Project# 101060
14DRB-70118 VACATION OF PUBLIC RIGHT-OF-WAY

**CITY OF ALBUQUERQUE
PLANNING DEPARTMENT
February 11, 2015
DRB Comments**

PROJECT # 1010060

RE: Tract A, Airport Center

ENGINEER'S SEAL	CHILI'S UNIVERSITY BLVD & GIBSON BLVD	DRAWN BY DY
	MILES RD HAMMERHEAD PLAN	DATE 3/17/15
RONALD R. BOHANNAN P.E. #7868	TERRA WEST, LLC 5571 MIDWAY PARK PLACE NE ALBUQUERQUE, NM 87109 (505) 858-3100 www.tierrowestllc.com	2013086 HAMMERHEAD
		SHEET # JOB # 2013086

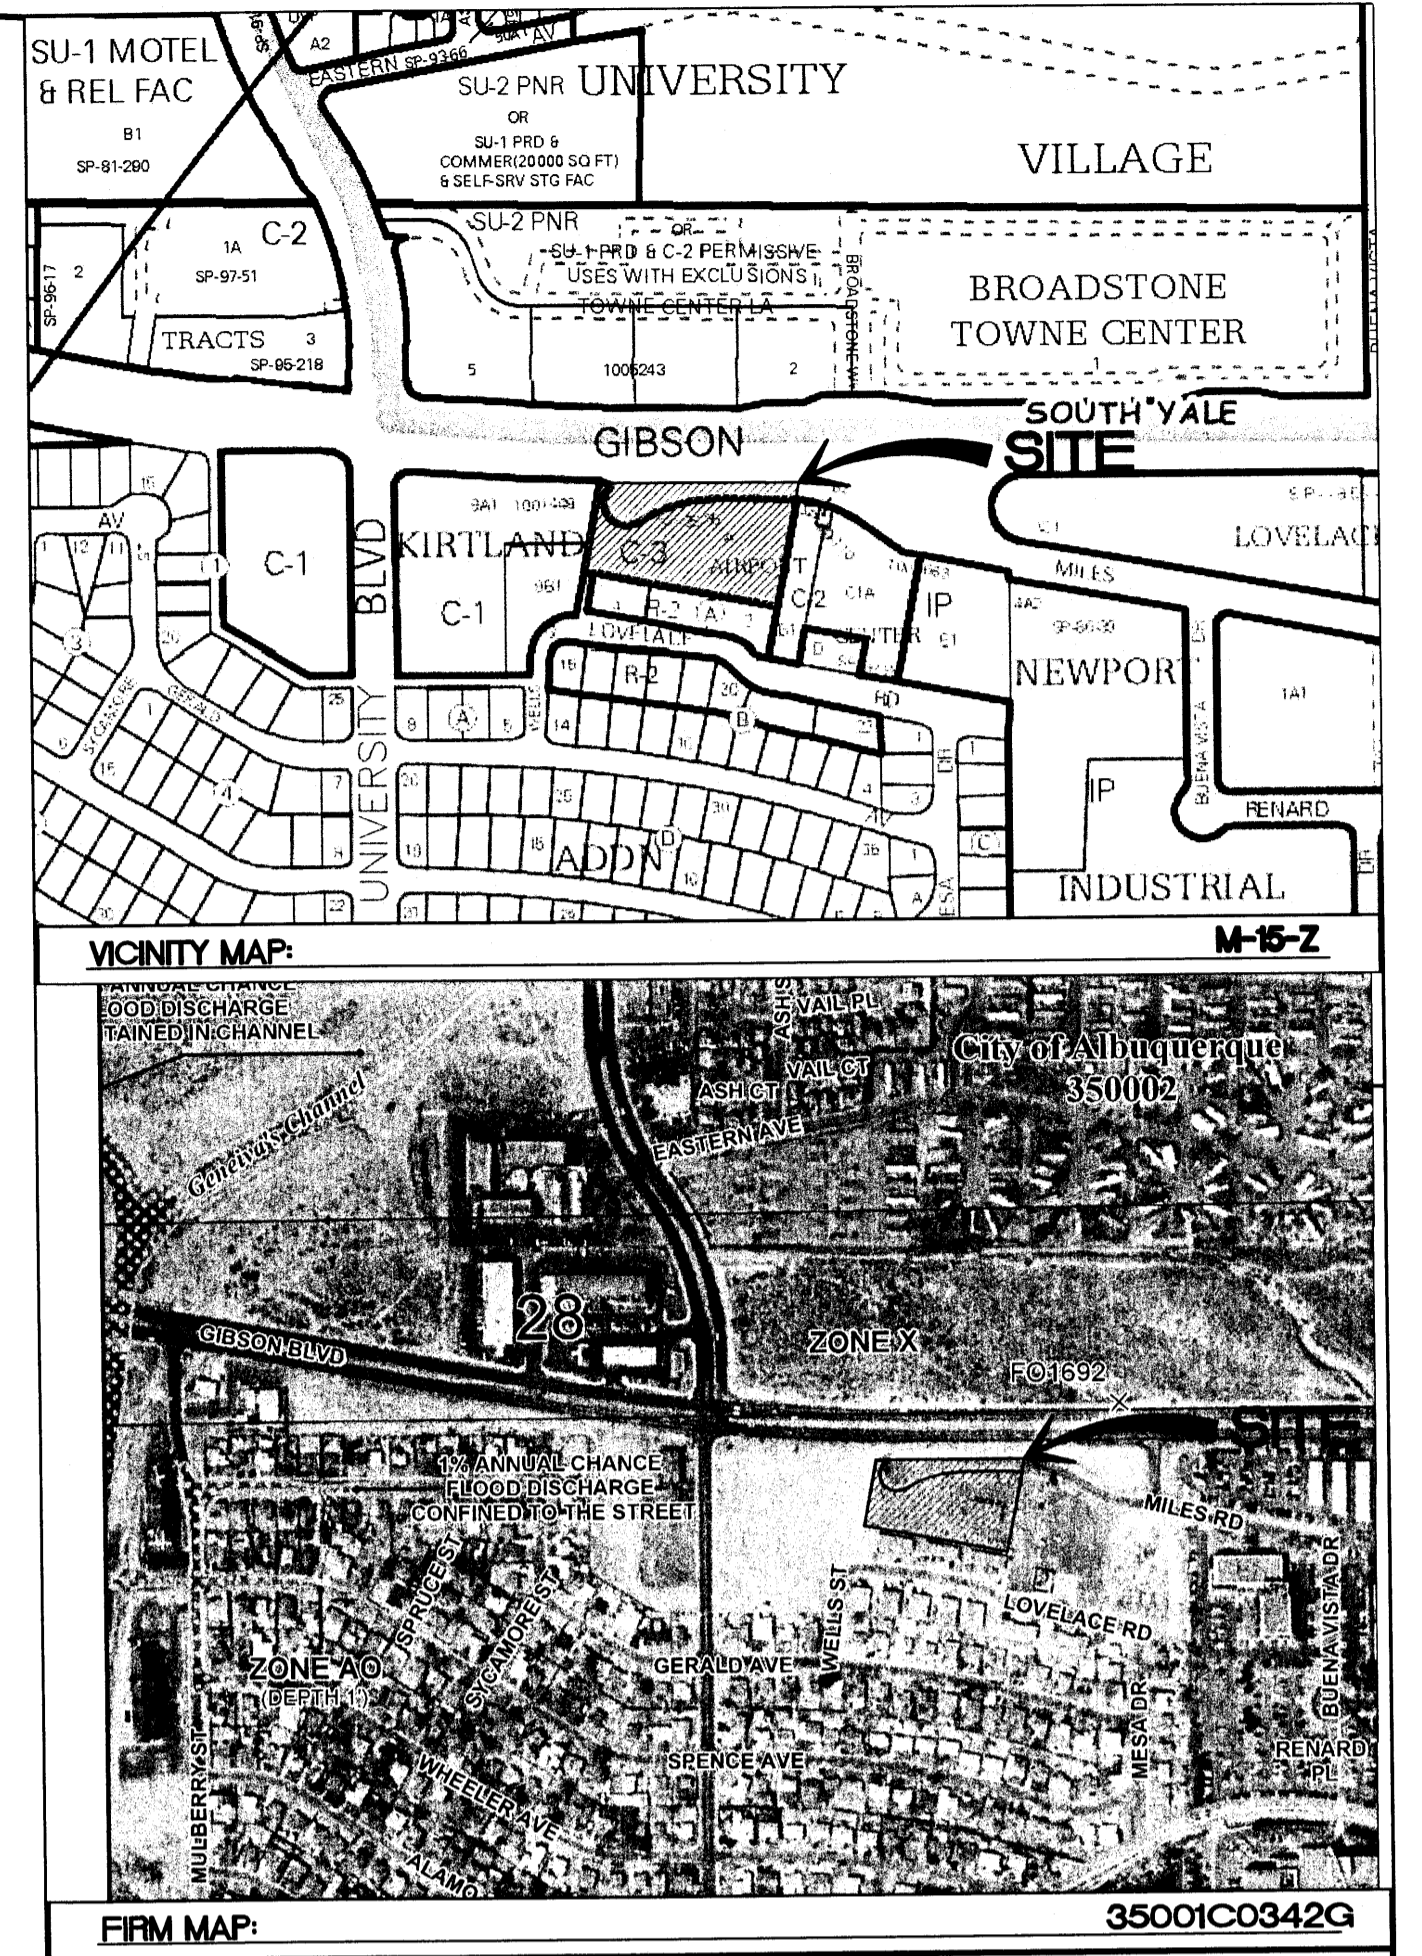
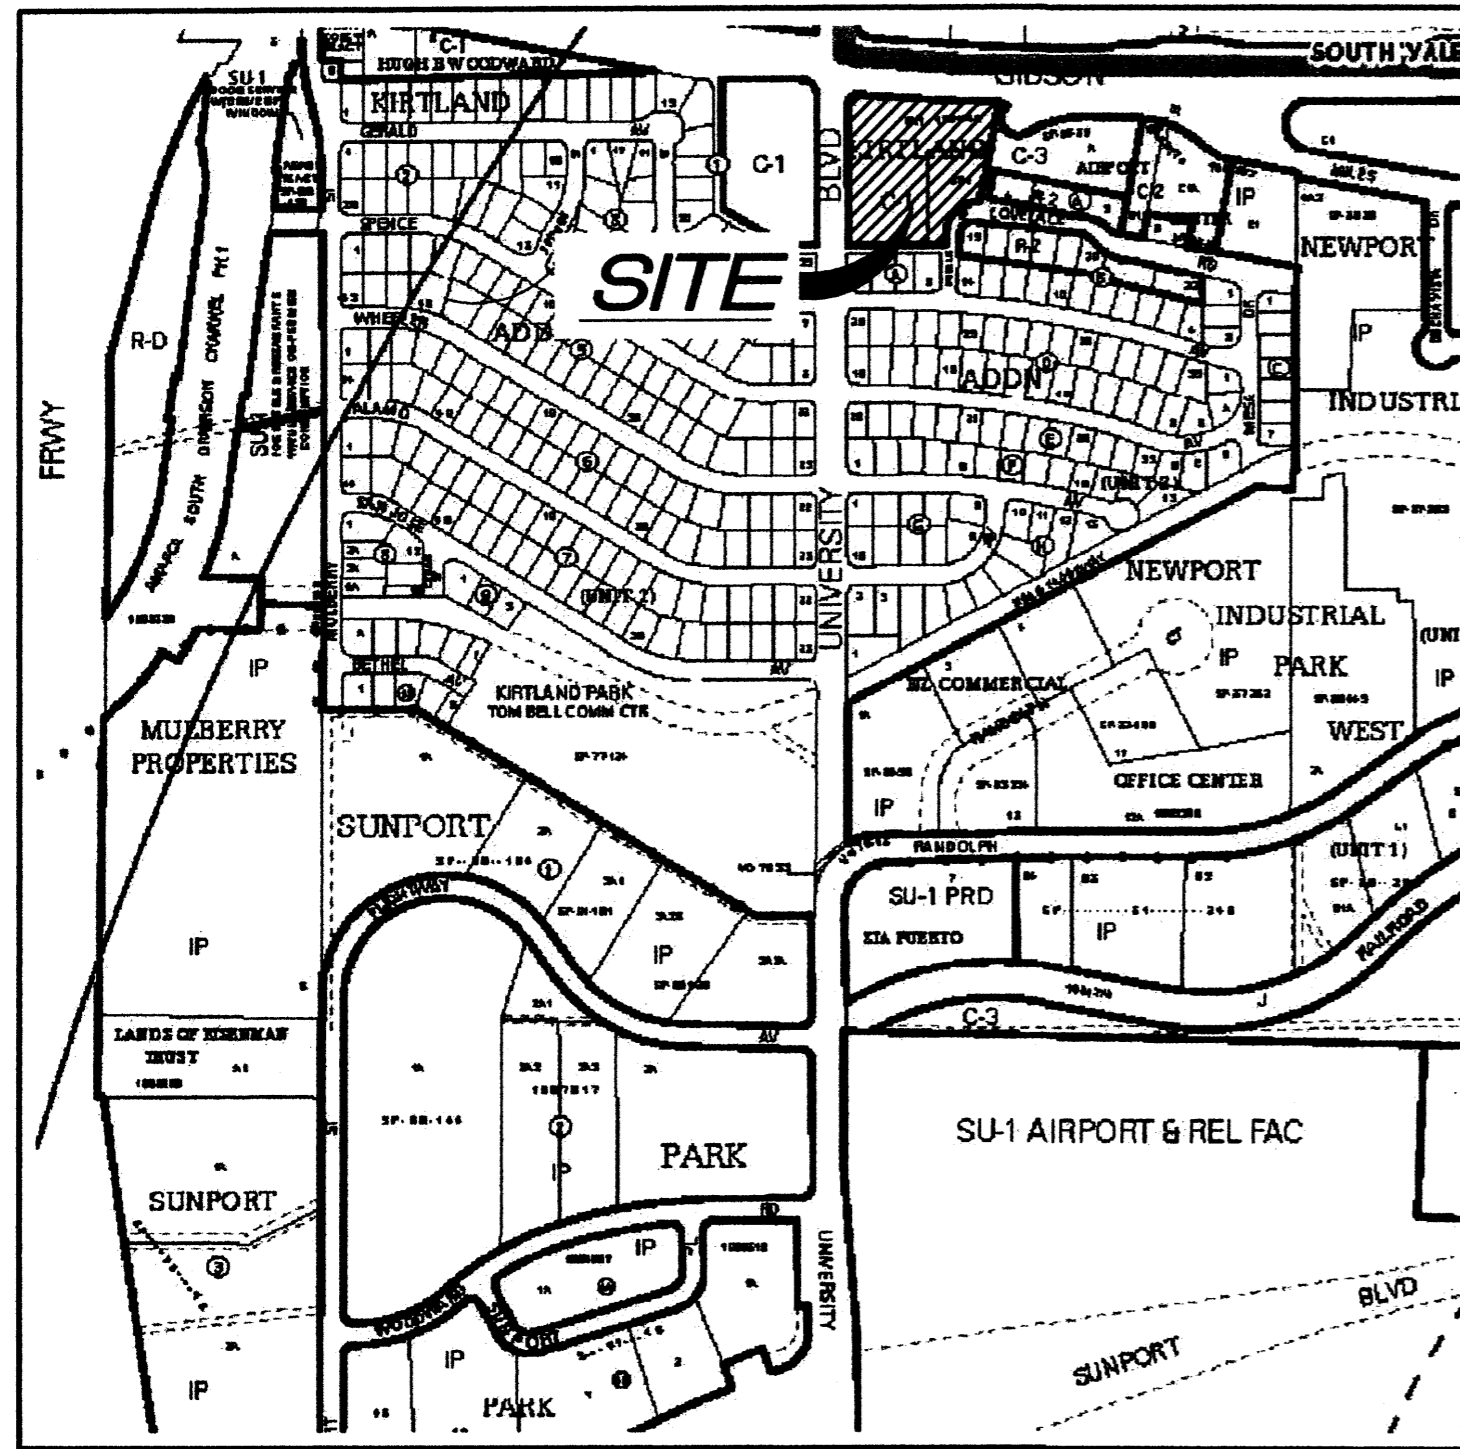
- The dimensioned 113' distance from the "Proposed Cul De Sac" to the "Right of Way to be Vacated" on the Turnaround Exhibit would be a 'stub street' in a Commercial C-2 zone. There is no legend with the submitted Exhibit so property lines weren't evident, but based on review of other parcel data the stub street would be serving three commercial properties; however the DPM standards for 'stub streets' are for residential streets/ lots only and are not allowed in this situation. The Vacation Exhibit(s) submitted **5-21-2014** with the vacation application and approved by DRB on June 4, 2014 should be referred to for an appropriate cul de sac location. An option to proceed as proposed would be to re-submit the vacation to include the right-of-way in front of the two properties to the east, such that the proposed cul de sac could be defined with a new right of way line. Obviously an easement would be required for this site to maintain access to Miles Road, but it may be possible to retain most of the existing paving with an appropriate curb/ drivepad along the radius of the proposed cul de sac.

- There is a significant 4' (or more) grade difference from the sidewalk on Gibson up to the existing paving of Miles Road at the proposed Cul De Sac. Again there is no legend with the Turnaround Exhibit, but there appears to be a fence or a wall near the Proposed Cul De Sac and at the back of the sidewalk on Gibson. The City will not accept a wall in the right of way if it is a retaining (2' or greater) wall.

- There is a significant electrical distribution line running south from the Transmission Line along Gibson, with an existing pole in the location of the Proposed Cul De Sac. Relocation options appear very limited, so approval by PNM would be needed prior to any DRB approval.

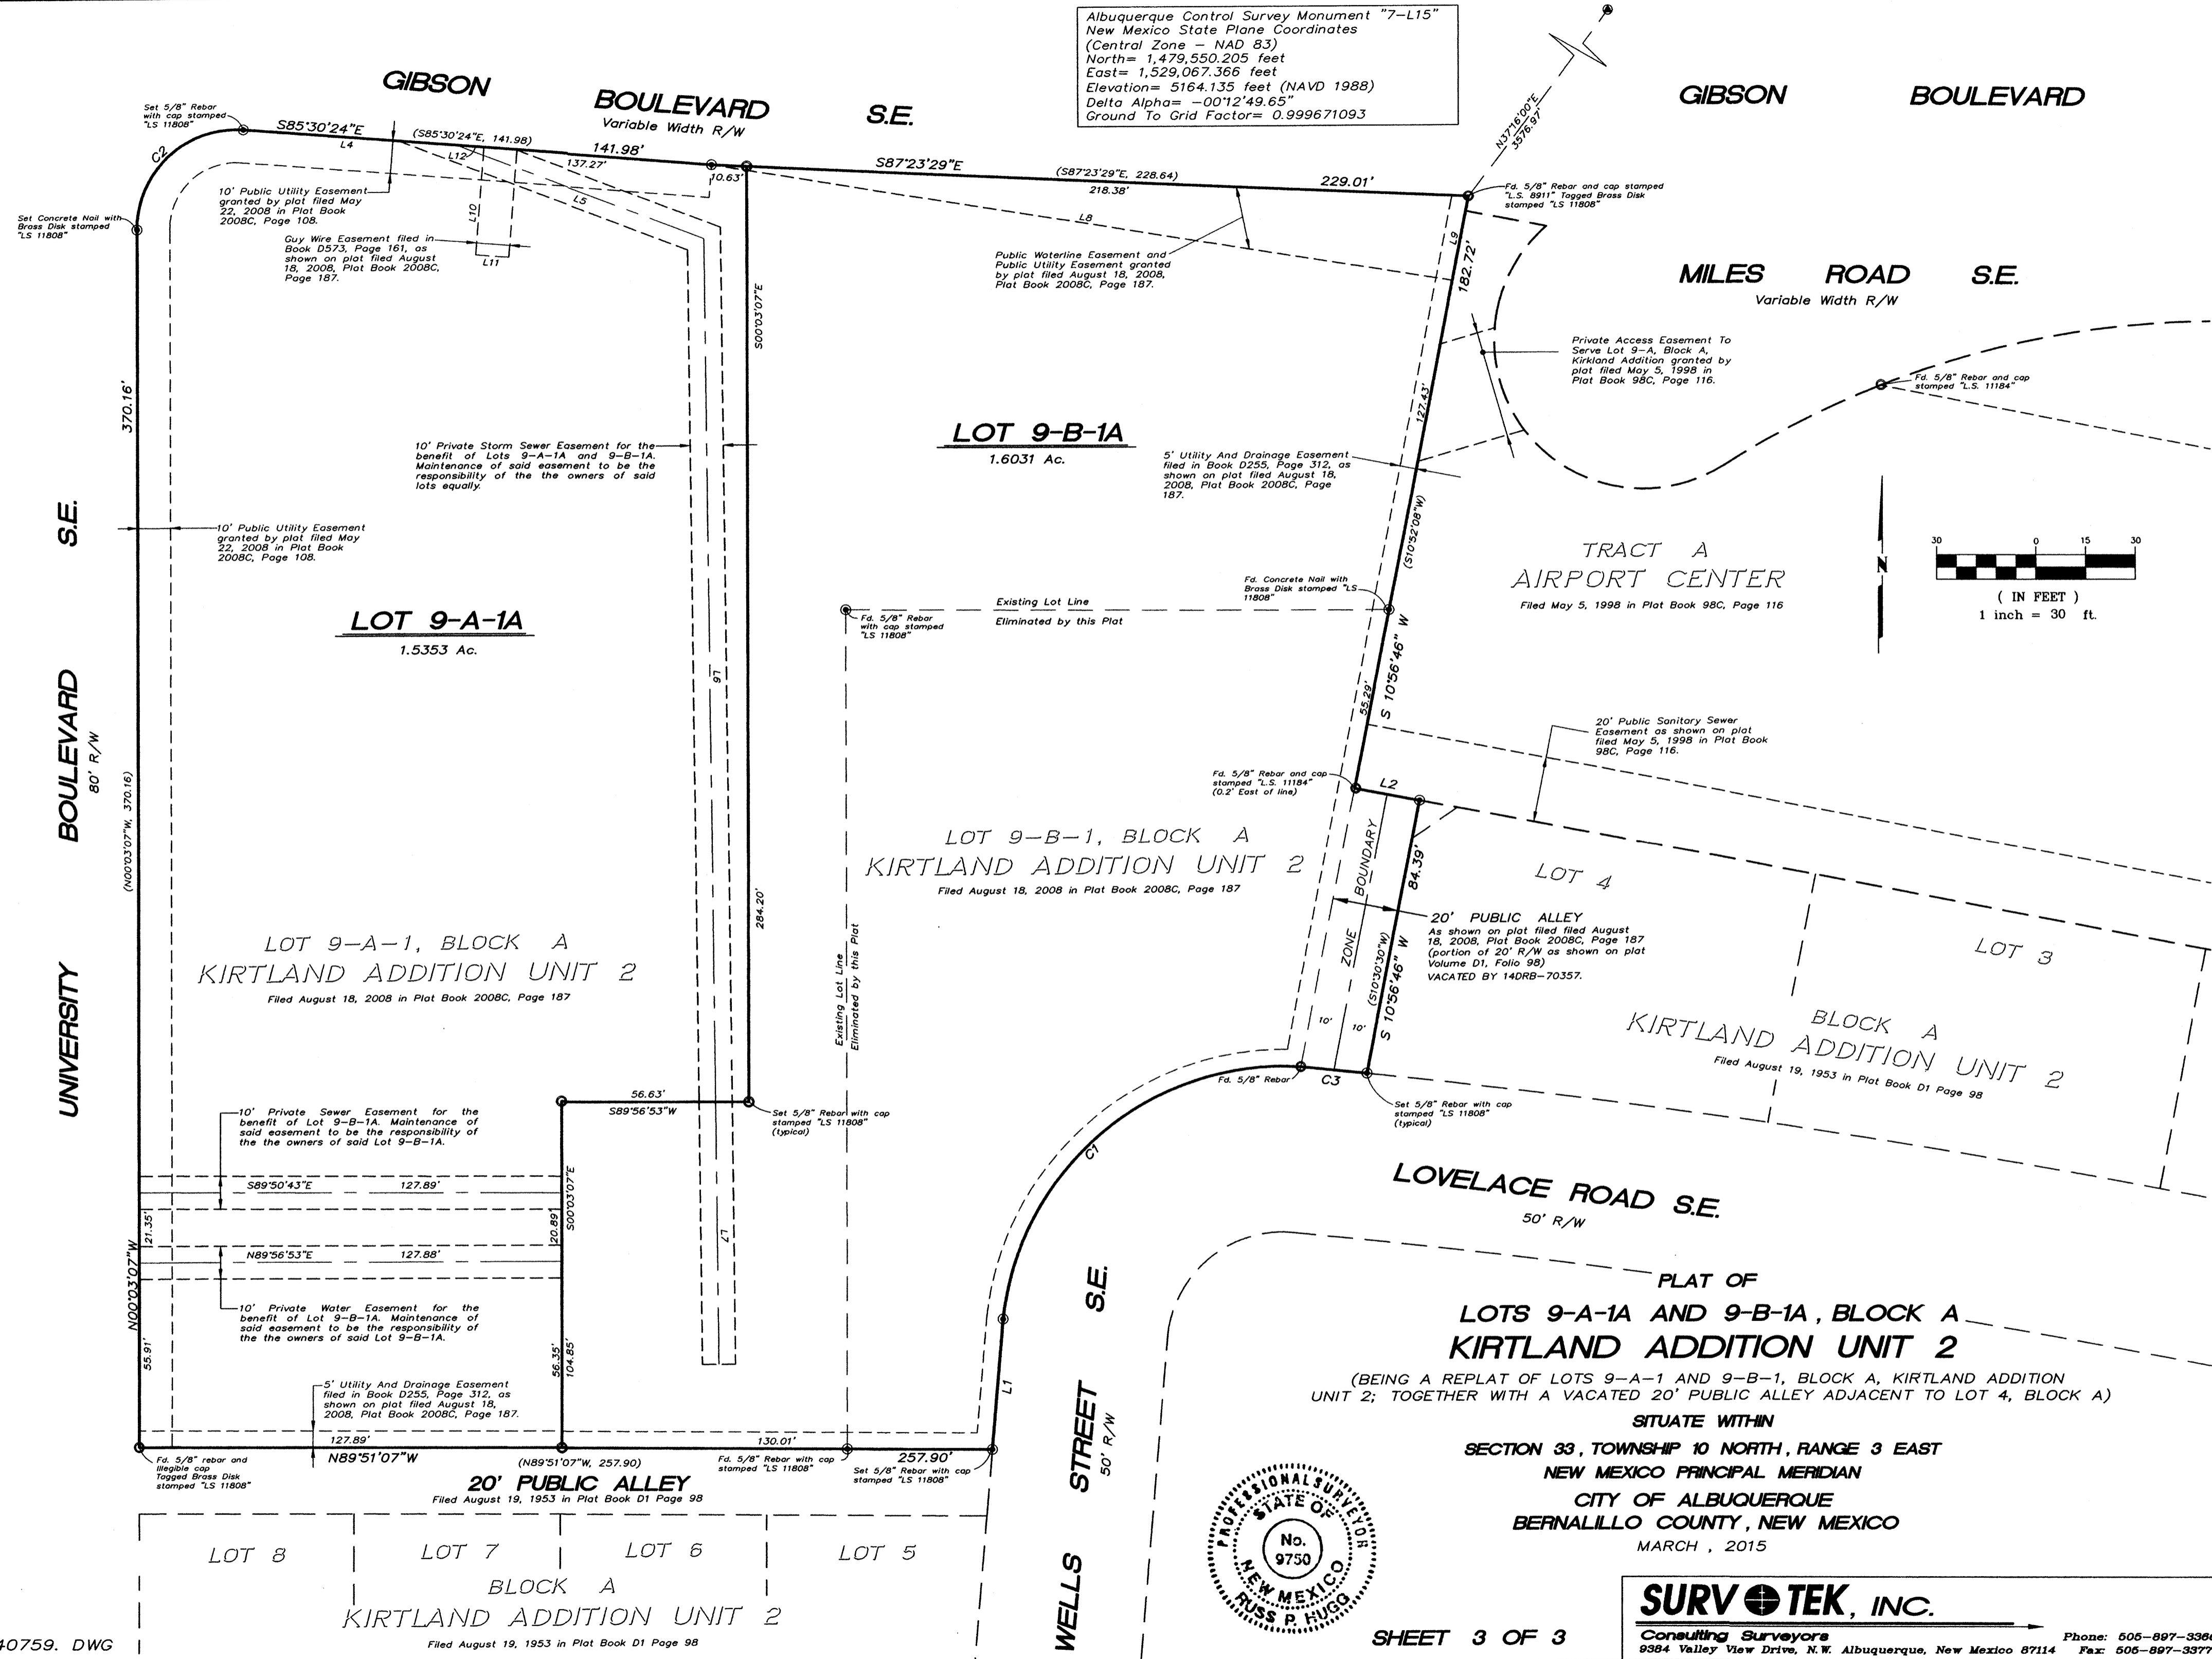
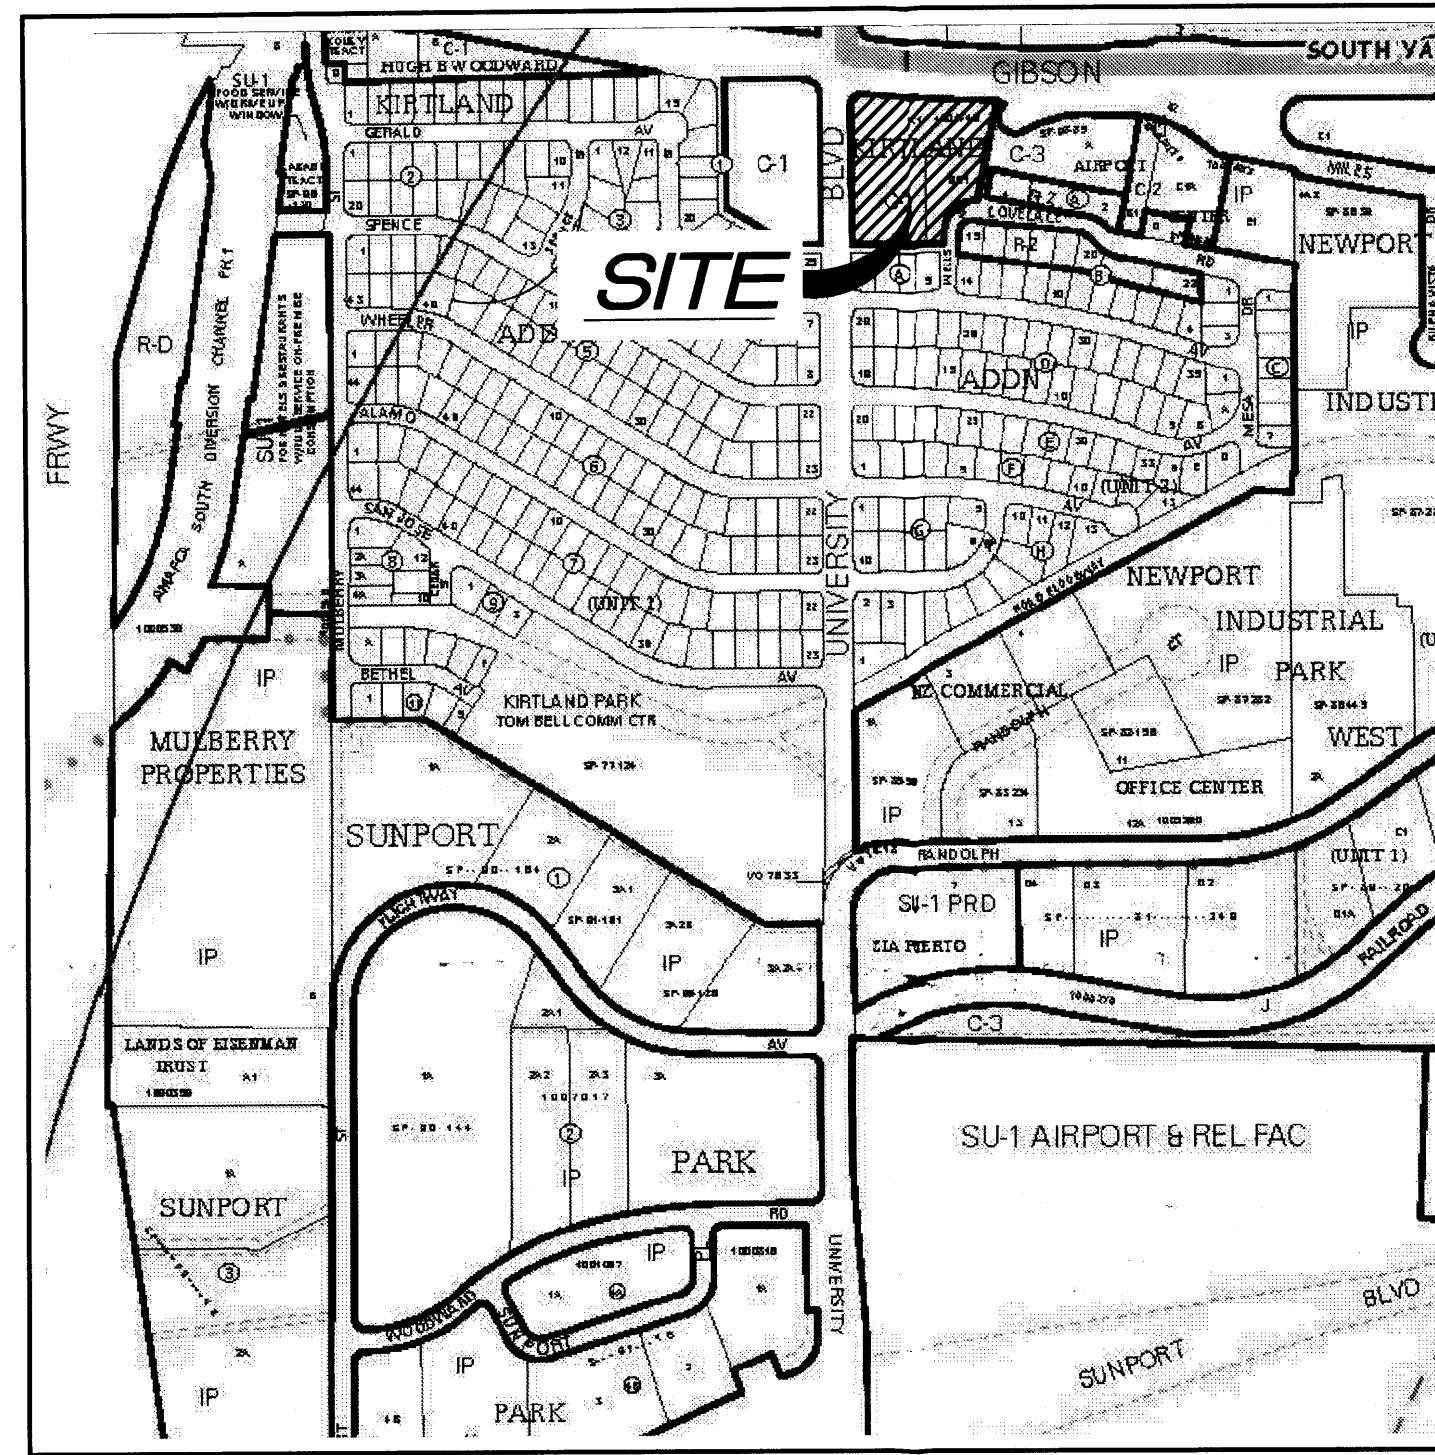
Even though the adjacent R-2 property owner may decline to acquire
the vacated right of way, the eastern half of the vacated alley is
zoned R-2 unless a zone change is approved; a centerline of the
alley needs to be shown on the plat and labelled "ZONE
BOUNDARY."
